Application No: A/79/21/DOC
Site Address: Land at Dappers Lane Angmering Littlehampton
Description of works: Approval of details reserved by condition imposed under ref A/76/20/PL relating to Condition Nos 6 - Construction Management Plan and 27 - soils management plan.

The Construction Access Map shown in the documents listed for this Planning Application requires amendment before approval.

Appendix A
Construction Access Map

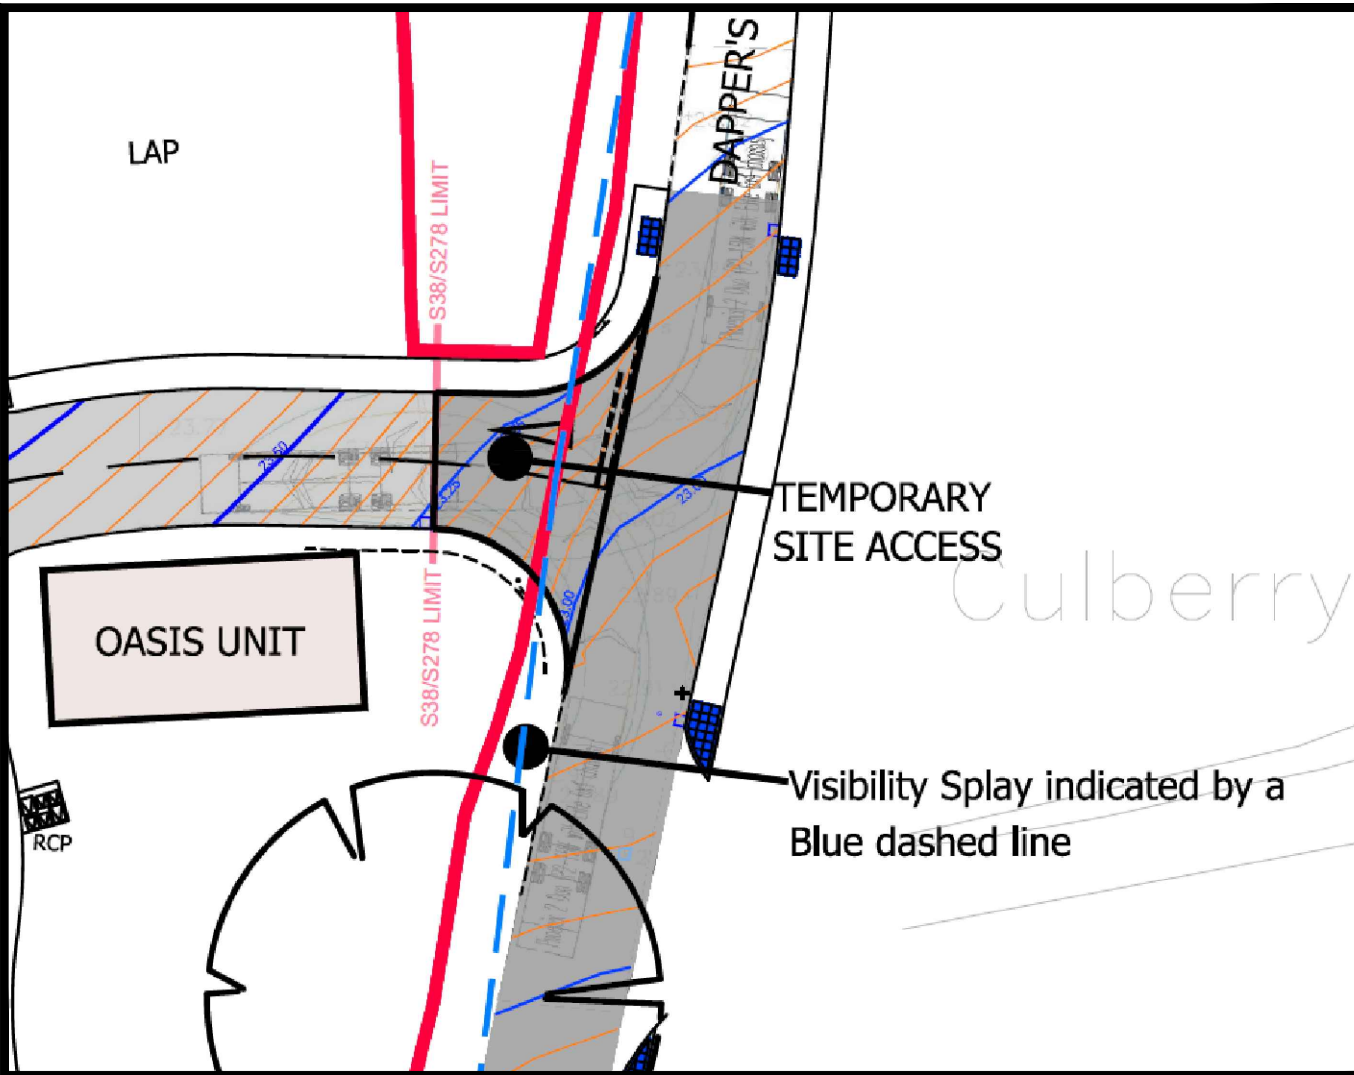
1. The Access Route allows if not recommends that HGV vehicles should pass through Angmering Village centre, Station Road & water Lane.
2. No instruction is included stopping HGV and other construction traffic approaching the site from the A27 via Arundel Road & Dappers Lane from the north using the underpass.
3. By recommending all HGV and construction traffic approaches and leaves the site from the south, users and residents of that section are being unduly subjected to pollution, nuisance and inconvenience when alternatives are available
